CROWN TRADING CENTRE – DESIGN ADJUSTMENTS
PLANNING ISSUE

INTRODUCTION

During the detailed design of the buildings, small adjustments have been made in order to reflect emerging legislation (notably fire legislation), introduced through quality improvements in building products, correct some small inconsistencies in the consented scheme, and as a result of feedback from third parties (notably the police). During these changes we have at all times maintained the vision established in the consented scheme. This report describes as simply as possible what those changes are.

- 1B2P Aff
- 2B3P Aff
- 3B4P Aff
- 3B5P Aff
- 1B1P Int
- 1B2P Int
- 2B3P Int
- 2B4P Int
- 3B5P Int
- 1B1P Pfs
- 1B2P Pfs
- 2B3P Pfs
- 2B4P Pfs
- 3B5P Pfs

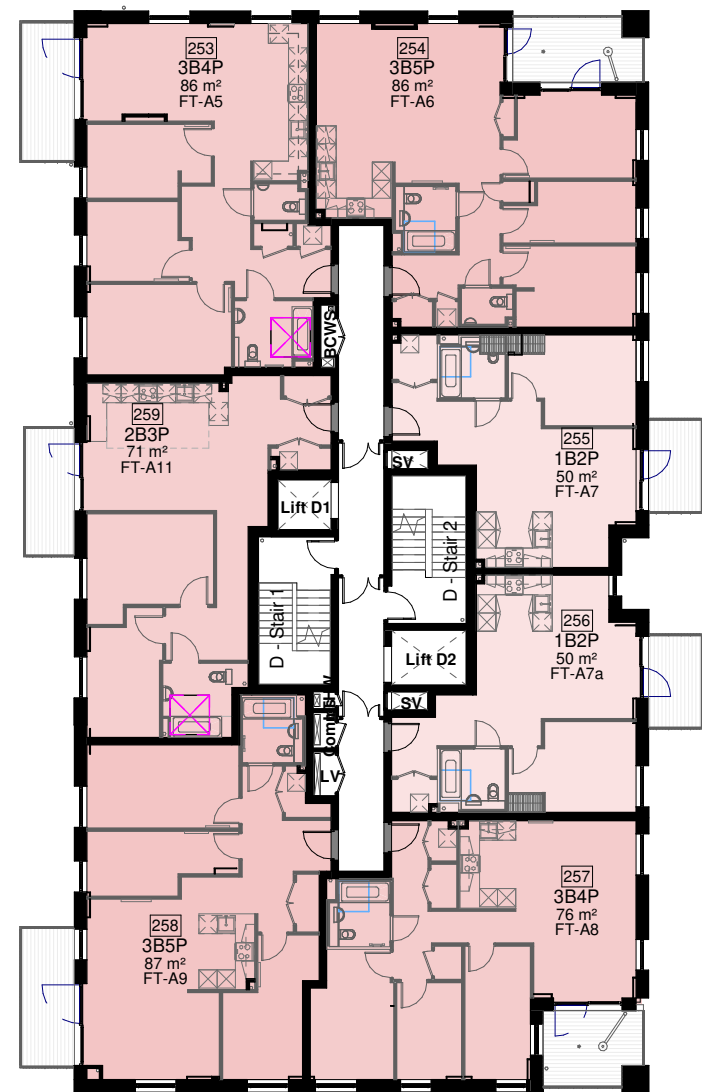
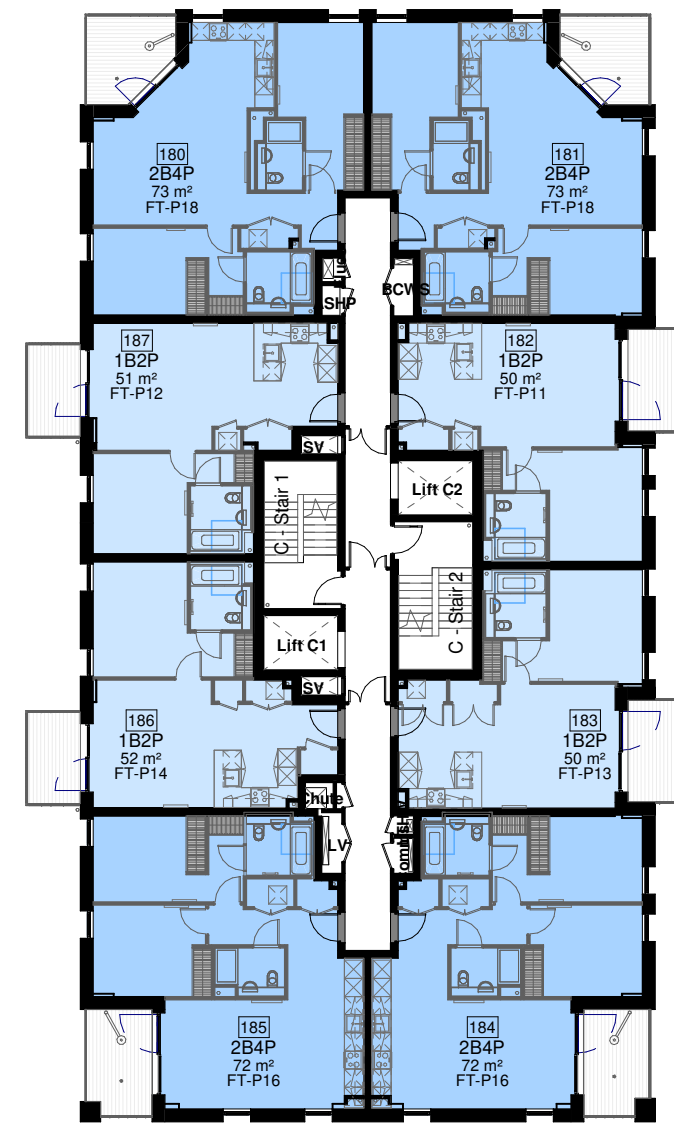
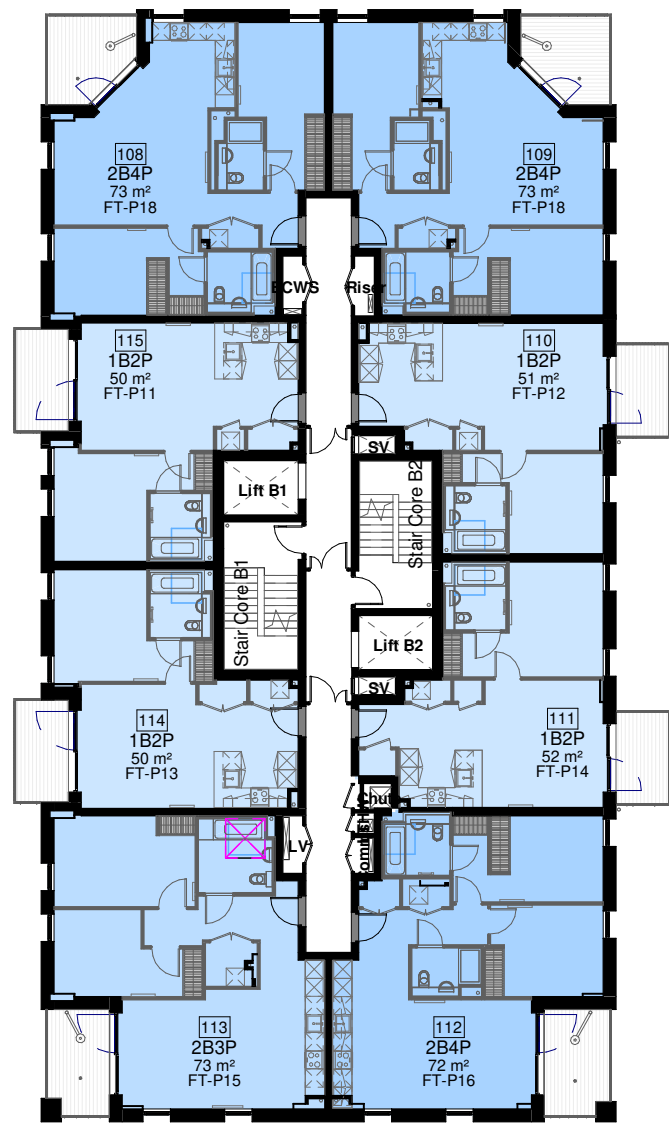
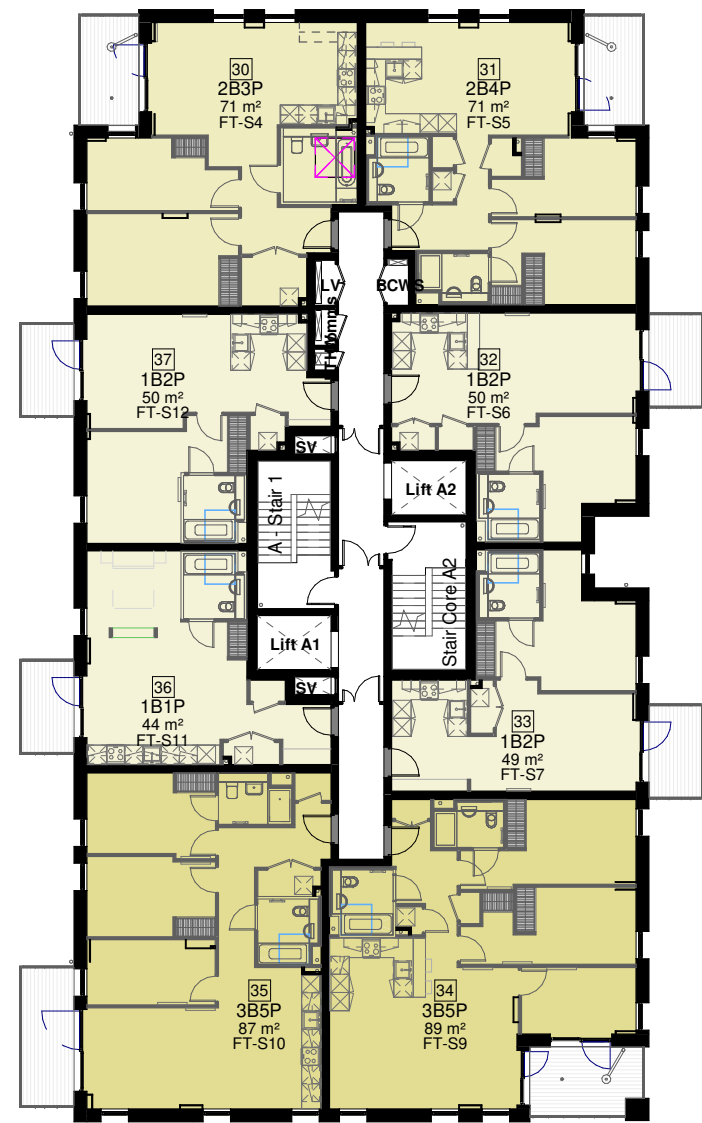
1. Lift and Stair positions amended to comply with emerging fire regulations
